From:
Sent: 21 July 2026 16:29
To: Katie Chew
Cc: DC Admin
Subject: Further Objection to 2026/91657 – Four-Storey Plot 23 Mischaracterised as a “Minor Material Amendment”

Mischaracterisation of the Garden Room as a “Minor Material Amendment”

This further comment responds specifically to AK Planning’s claim that the proposed lower-ground garden room constitutes a “minor material amendment” because it merely encloses an approved raised terrace.

Rear/south east facing elevation (1:100)

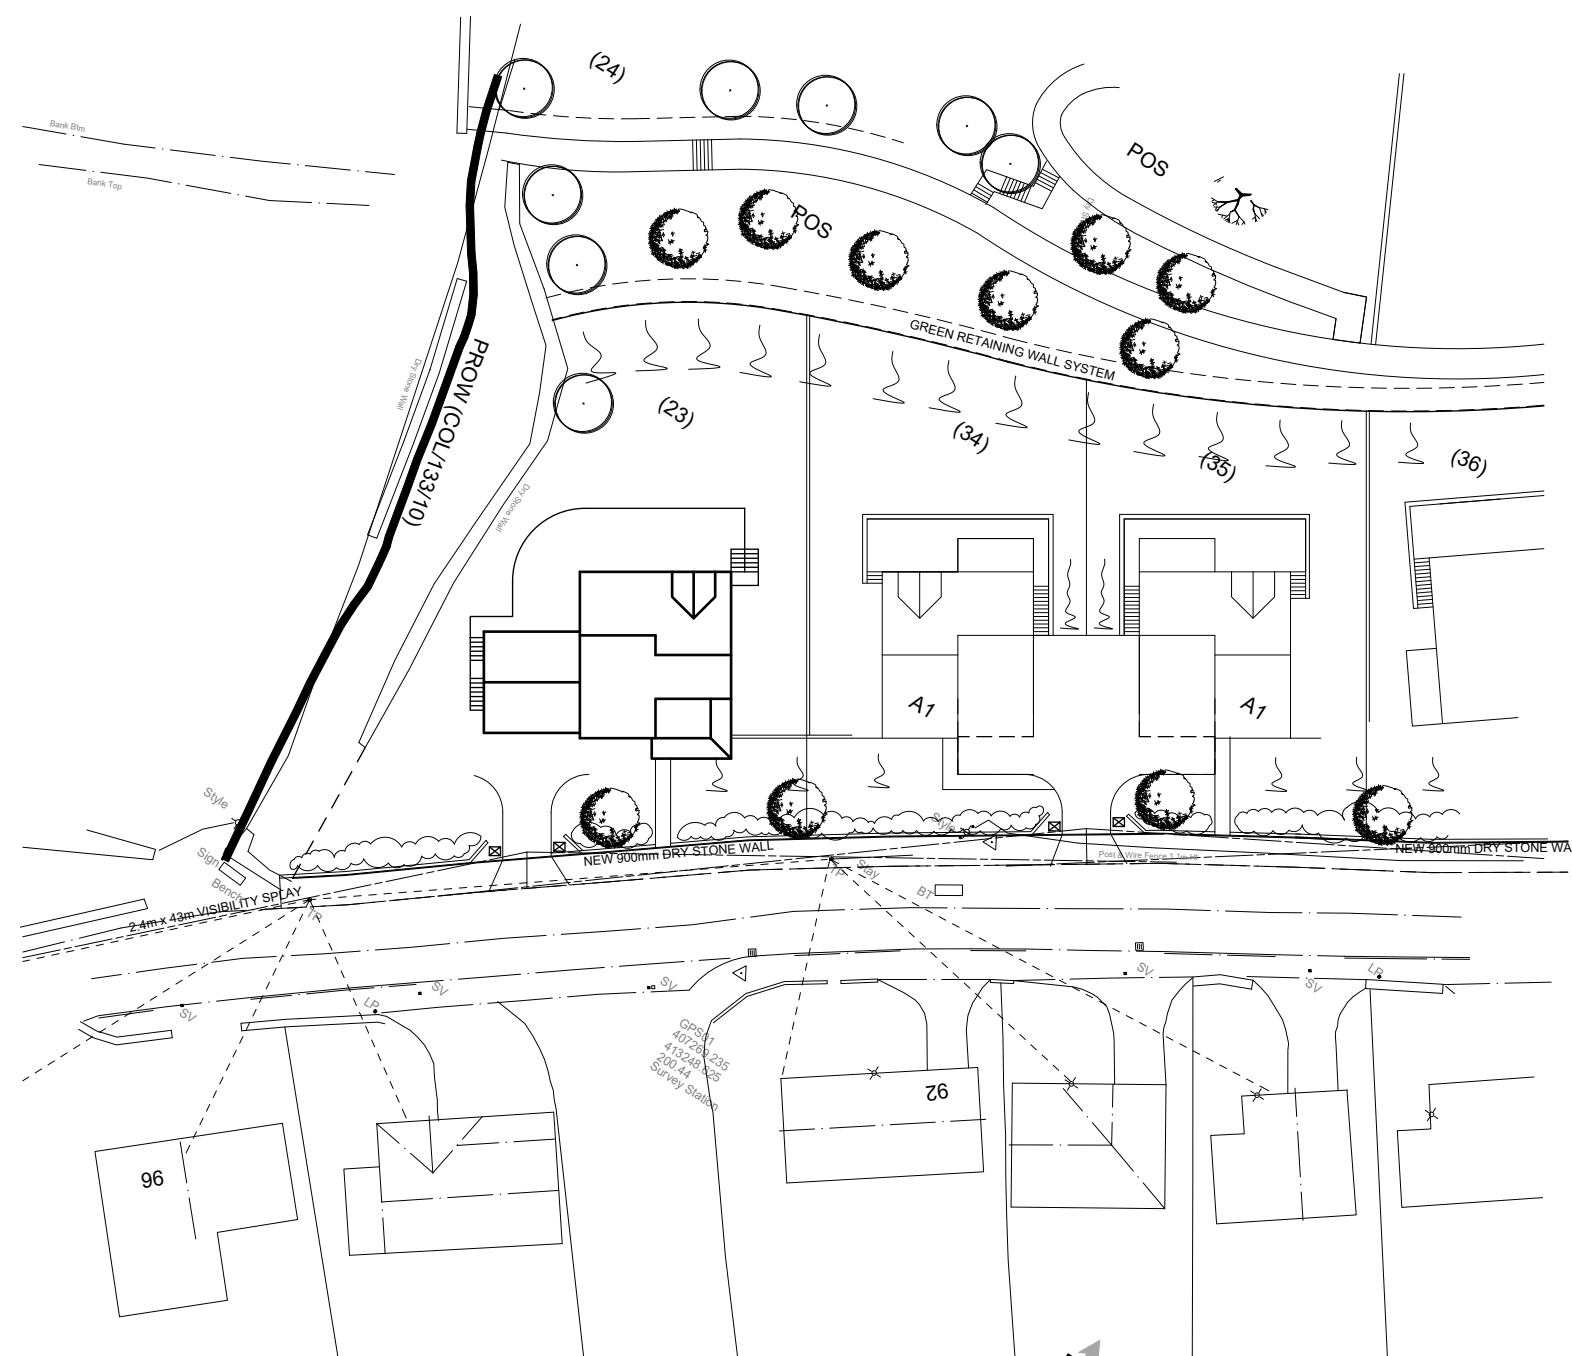
As detailed in my previous comment, its position, dimensions and level depart from the operative approved drawings. Those departures include an enlarged footprint, eastward displacement and a constructed level potentially approaching one metre above that shown.

- window openings had been formed;
- external-door openings had been constructed;
- PIR insulation and inner blockwork had been installed; and
- some of the window openings were subsequently infilled.

That sequence is consistent with the space having been designed and constructed as an enclosed room from the outset, rather than the garden room resulting from a later decision to enclose an open terrace.

The planning significance of the garden room is not confined to the installation of glazing or the enclosure of an open area. It forms the additional lowest level of a building that now presents as four vertically connected storeys.

As explained in my previous comment, the structure's roof forms the raised patio reached directly from the lower floor. Its elevation establishes the datum from which the remaining floors and roof rise. The additional lowest level is therefore physically and vertically integral to the complete building.

1. reject AK Planning's characterisation of the proposal as merely the minor enclosure of an approved terrace;
2. assess the complete development against the operative approved drawings;
3. investigate the construction sequence and determine whether it constitutes intentional unauthorised development;
4. consider the cumulative change in scale, height, massing and number of storeys;
5. refuse the application; and
6. if the development is not brought into conformity voluntarily, take appropriate formal enforcement action.
